### ADDENDUM 3

**SUBJECT: Gladstone and Loretta Redevelopment Review of Proposed Changes**

Ownership at the CLV Group wish to pursue changes to the planned redevelopment at Gladstone and Loretta Avenue. These changes include a revised phasing of work, with a new architectural team focusing on the first phase — Tower A (formerly Tower 3), and additional height for all 3 towers. The conservation of the Standard Bread Building, a designated historic building, continues to be a feature part of this redevelopment. The attached site plan illustrates the site layout, and the positioning and massing of the three towers. All three towers will be taller with the addition of typical floors.

**SOUTH SITE ELEVATION -
PHASE 2 MASSING**

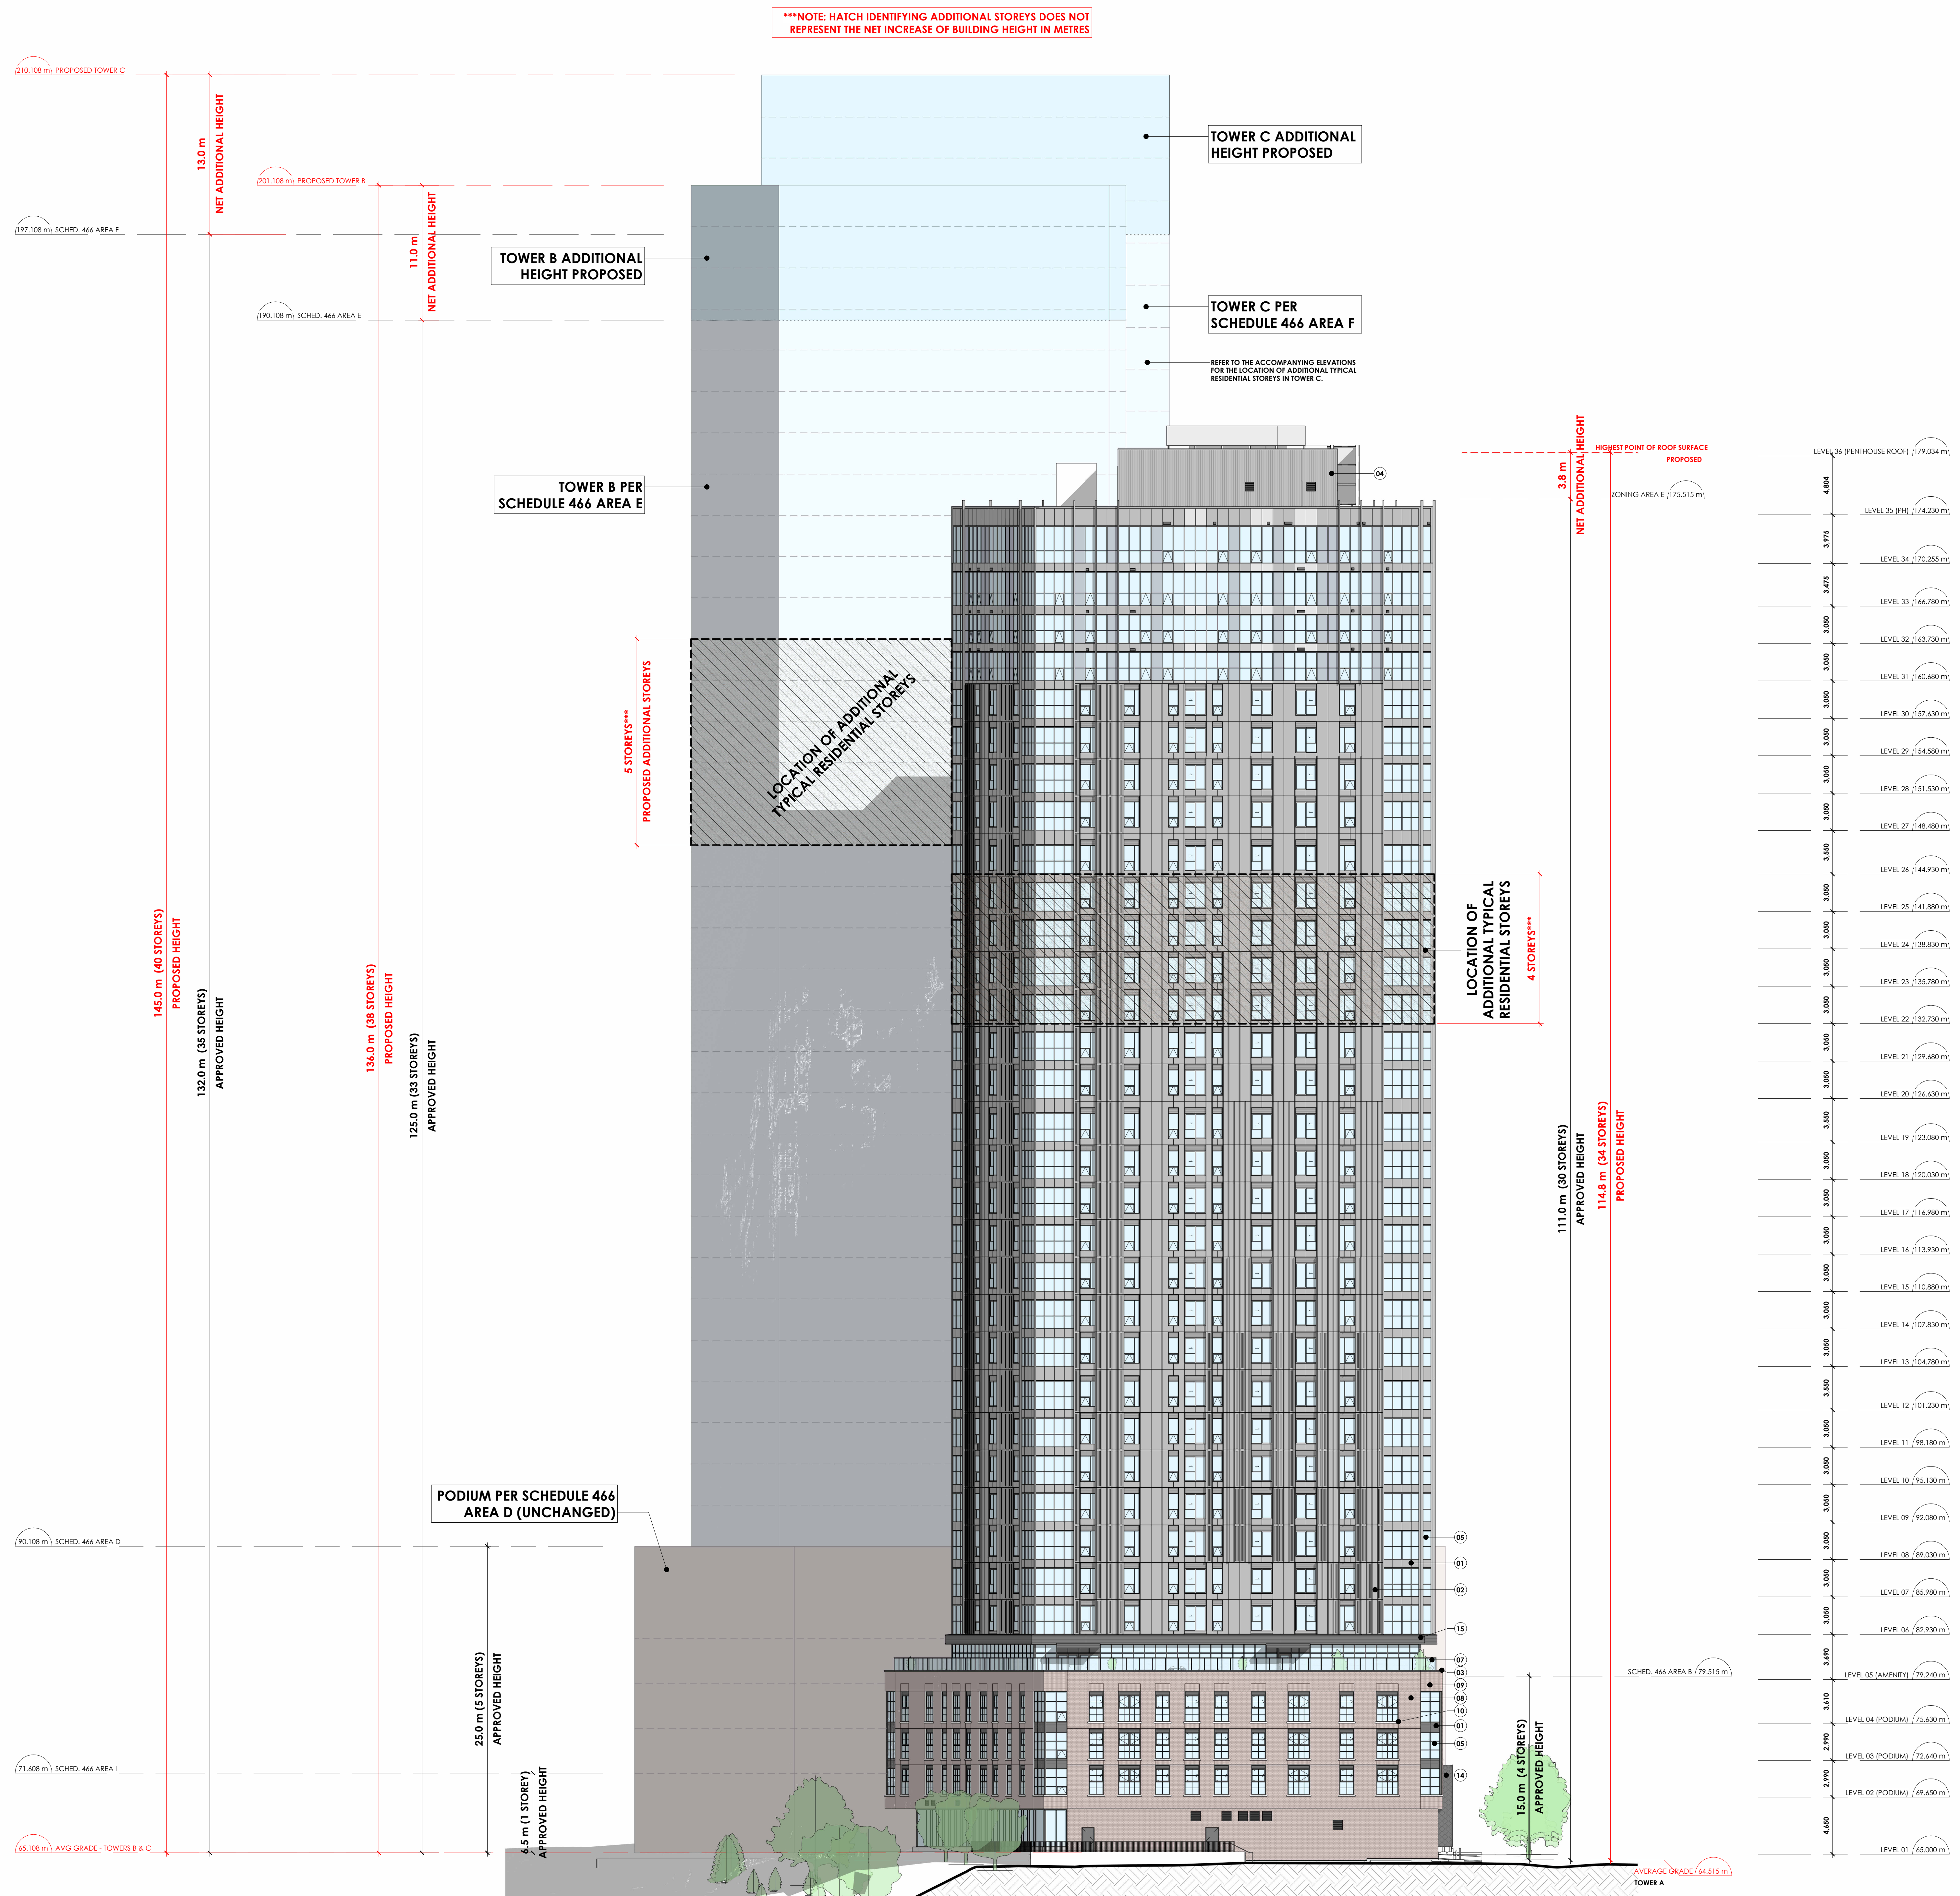
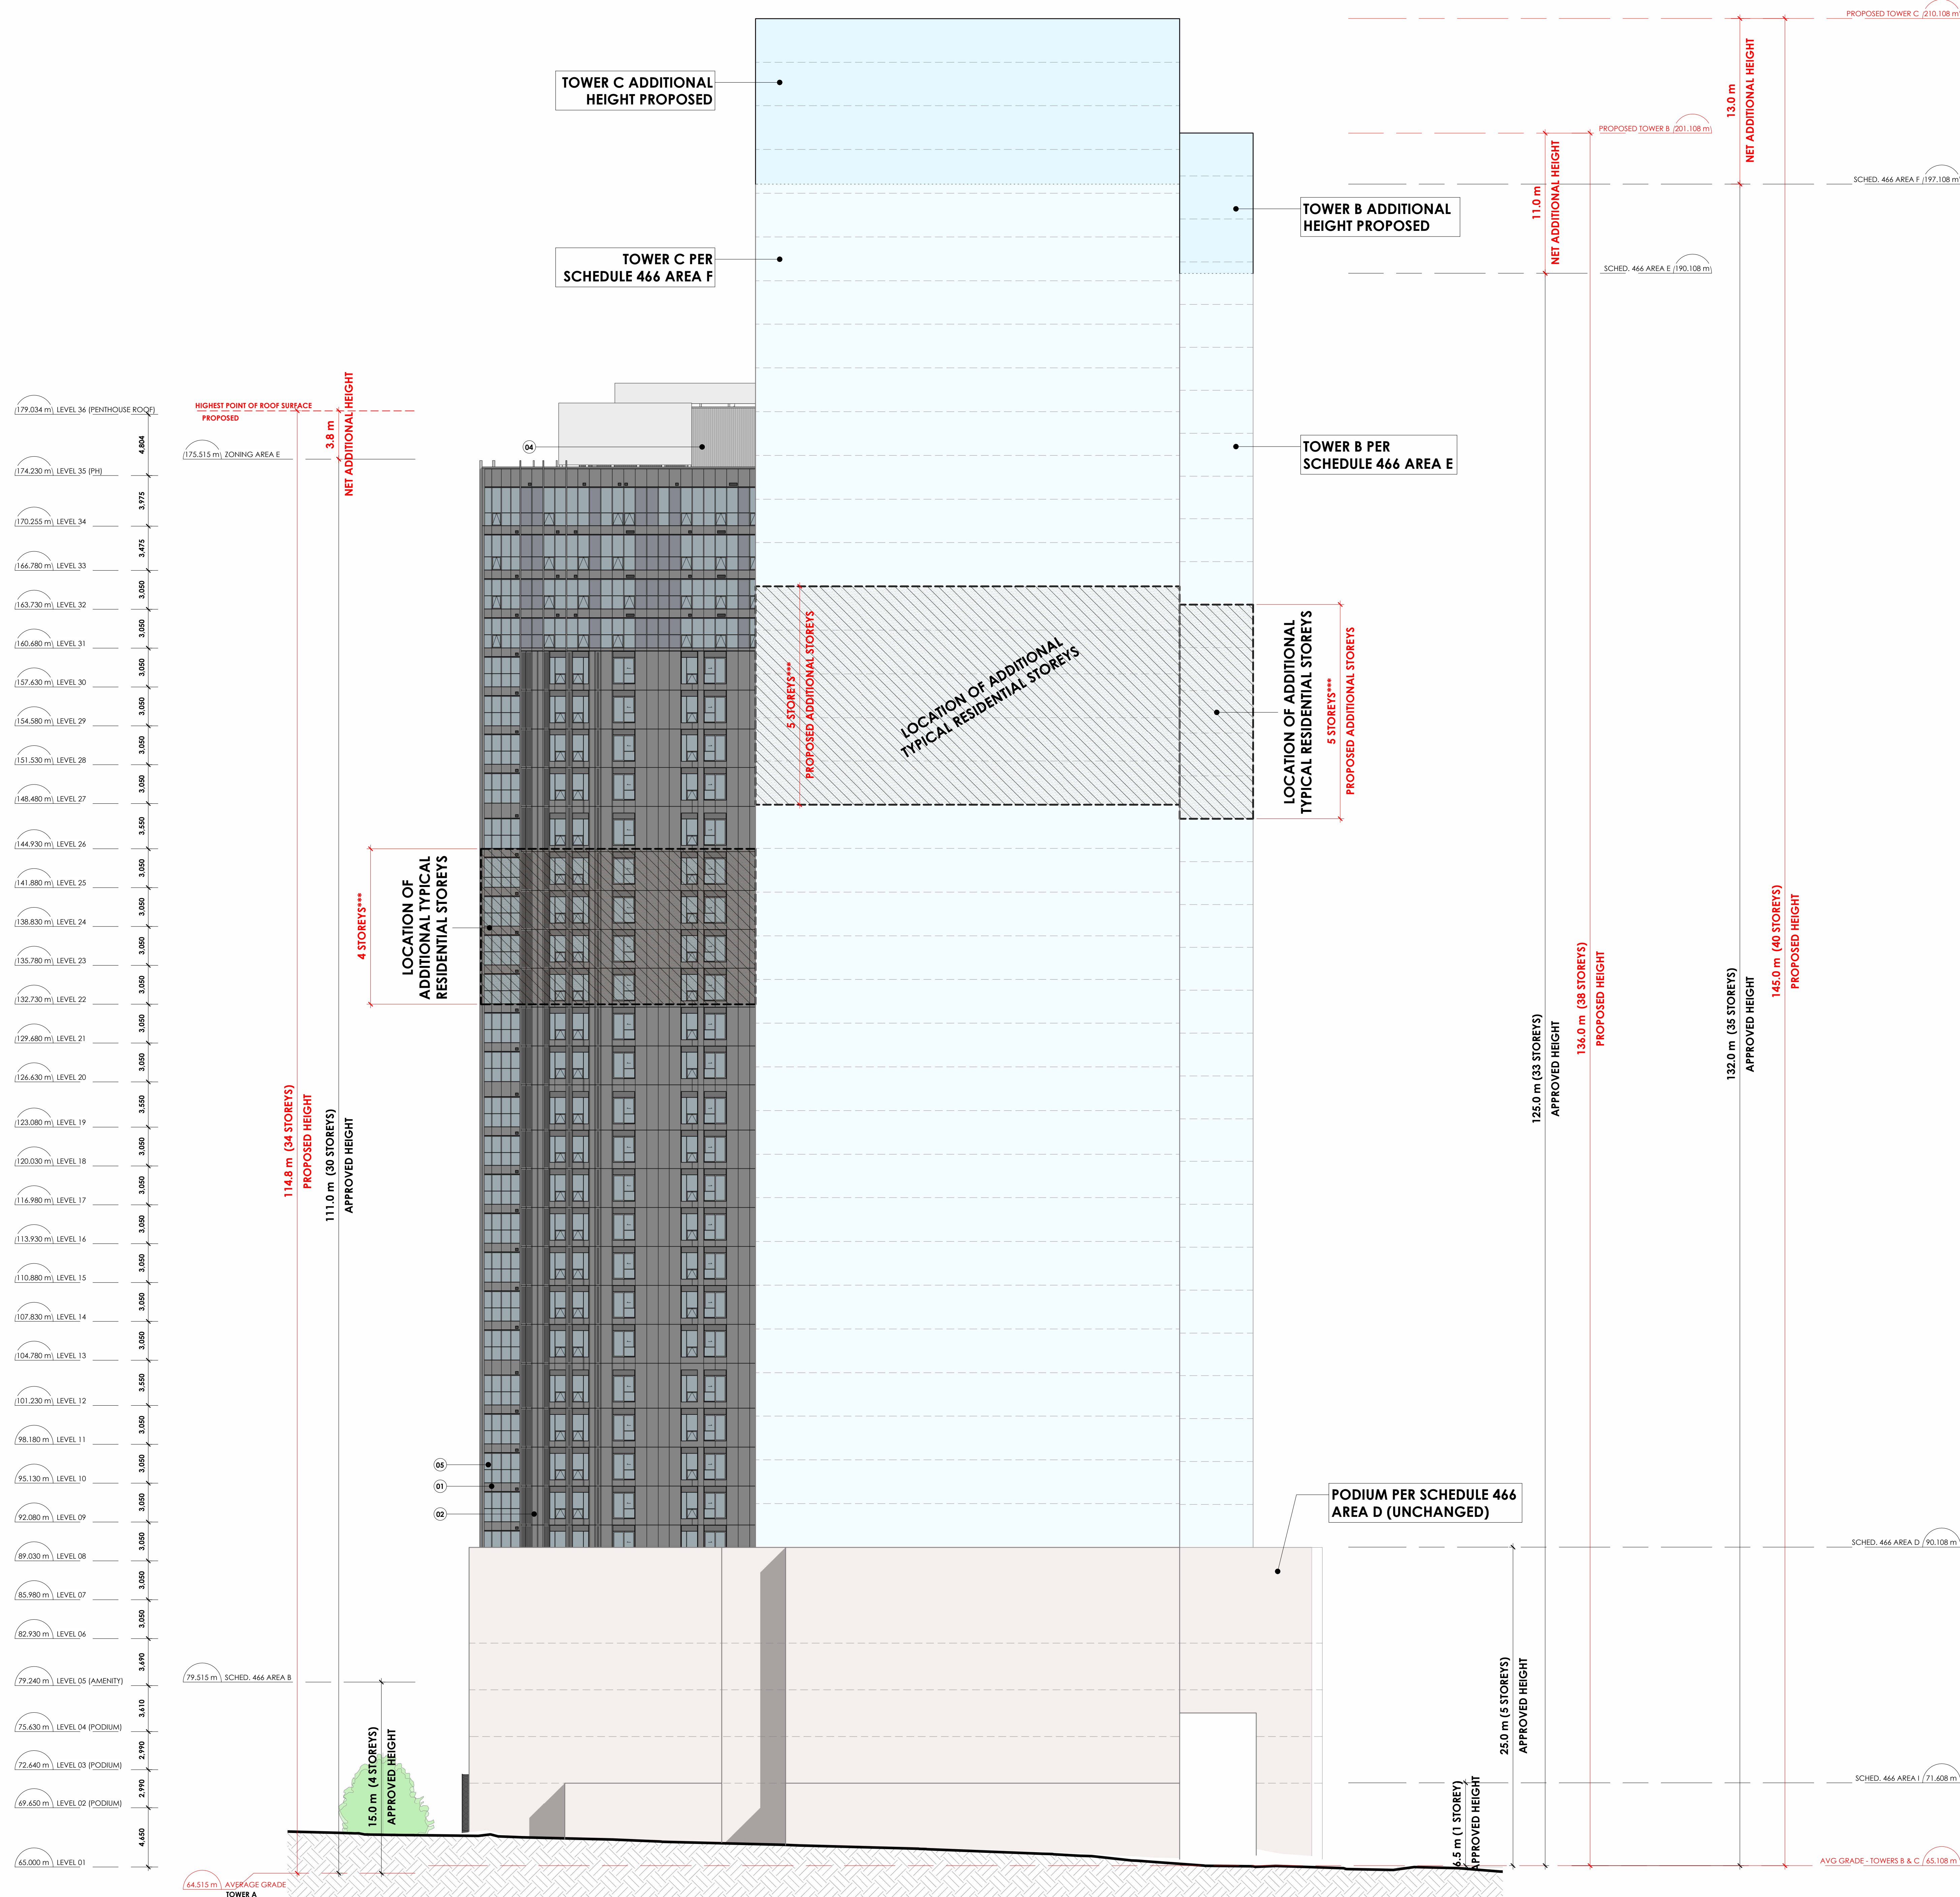
- *The proposed massing of the three towers respects the Standard Bread Building and reflects a pedestrian-scale along the street. The three proposed high-rise towers are set well back from the adjacent streets to acknowledge this scale and character.*

- *Along Gladstone, the podium height, and exterior finishes respect the height of the heritage building.*
- *On the west side of the building, the link between the new development and Standard Bread Building.*
